# Section 55

## Acceptance of Applications Checklist

## East Midlands Gateway phase 2 Section 55 Acceptance of Applications Checklist

ACTIVE TRAVEL LINK (SECTION A) LONGSECTION
SCALE: H 1:2500, V 1:500. DATUM: 85.000

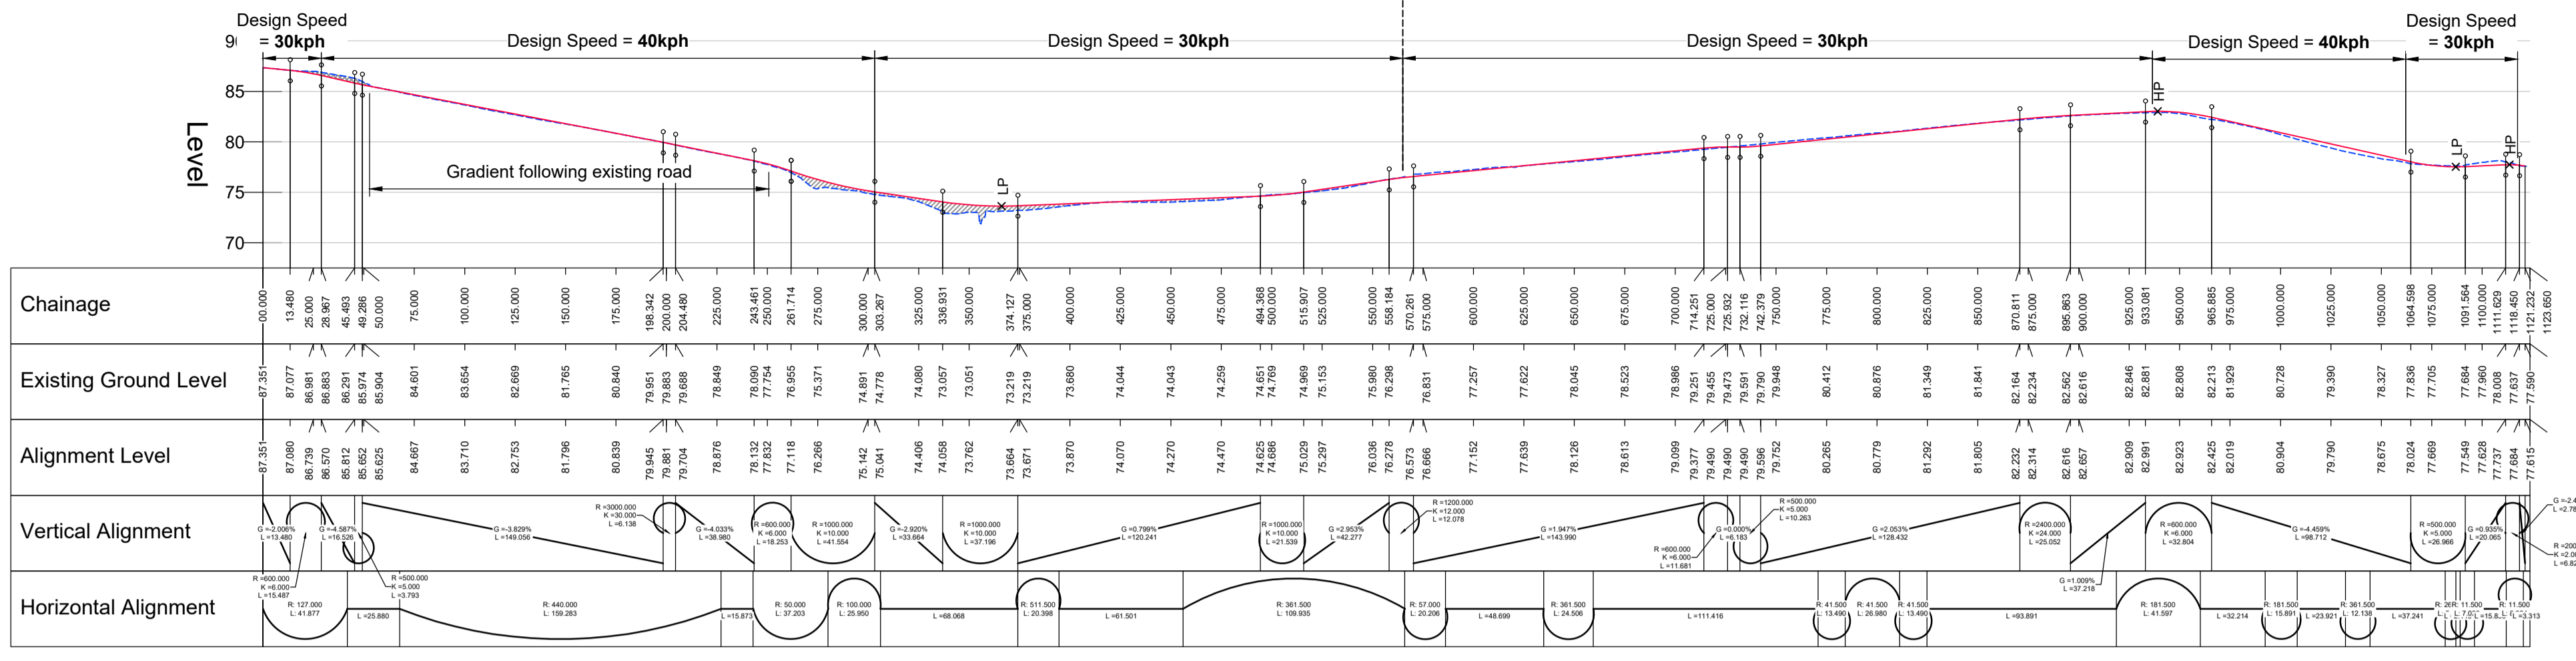
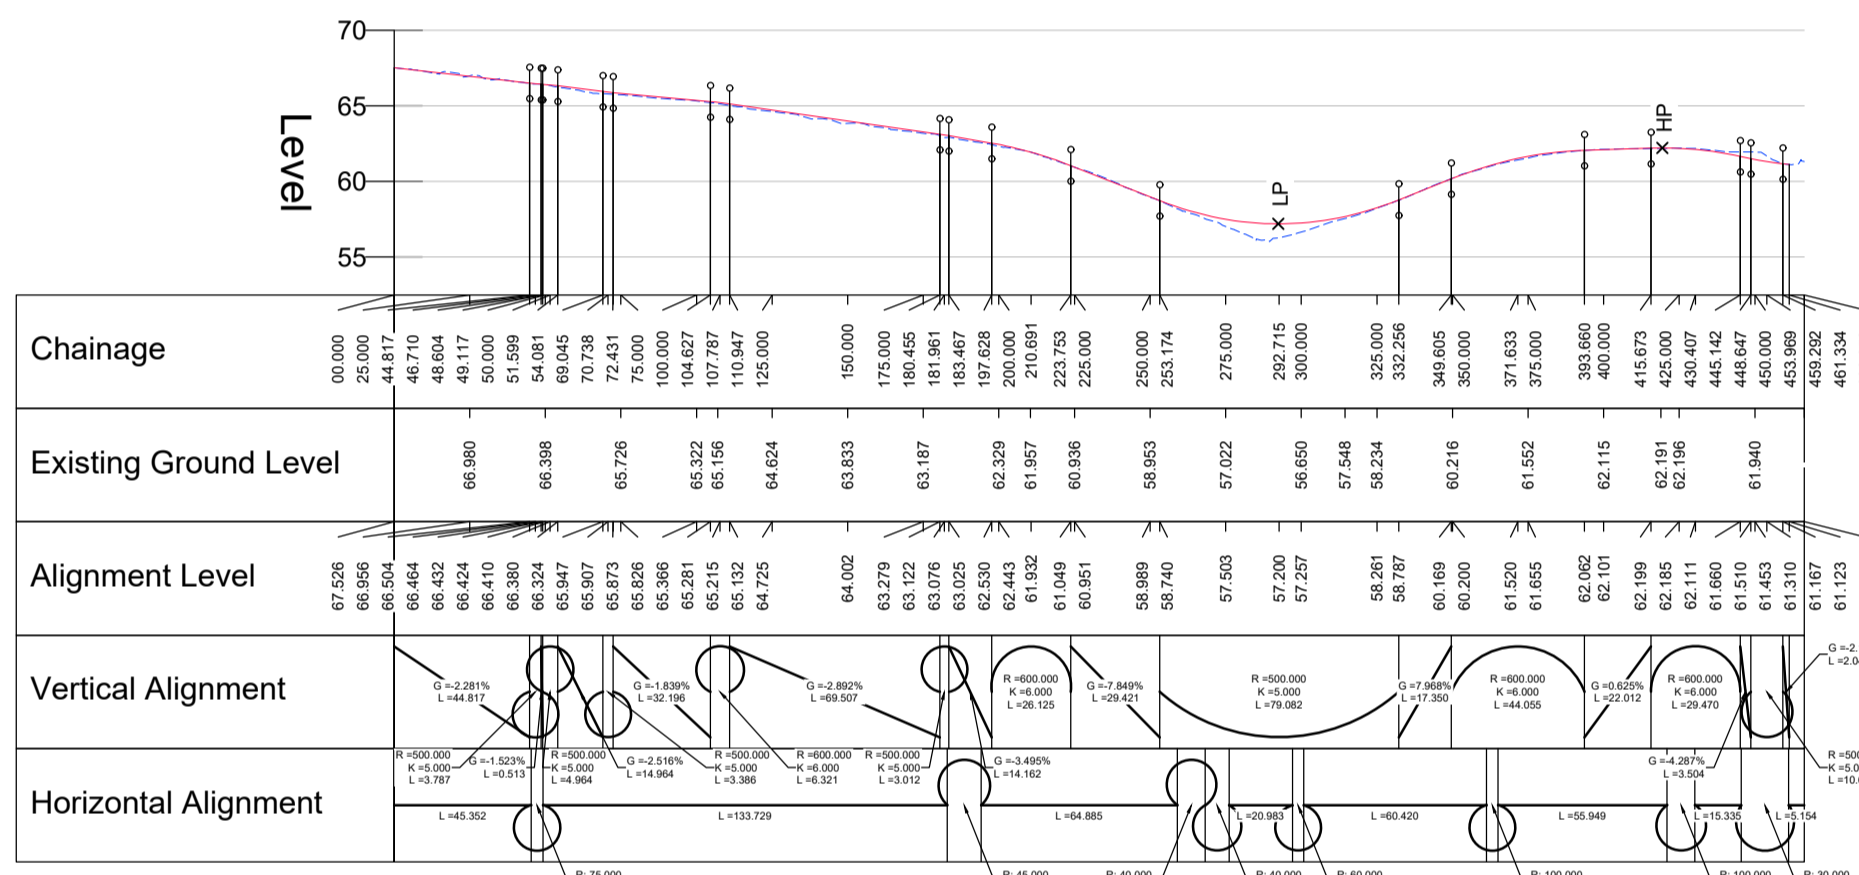
Colours used in the Legend for marking the *Proposed Design* and *Chainage Lines* become difficult to distinguish when they cross or run next to each other. Consider altering to non-analogous colours whilst being mindful of the red colour used for *Order Limits*.
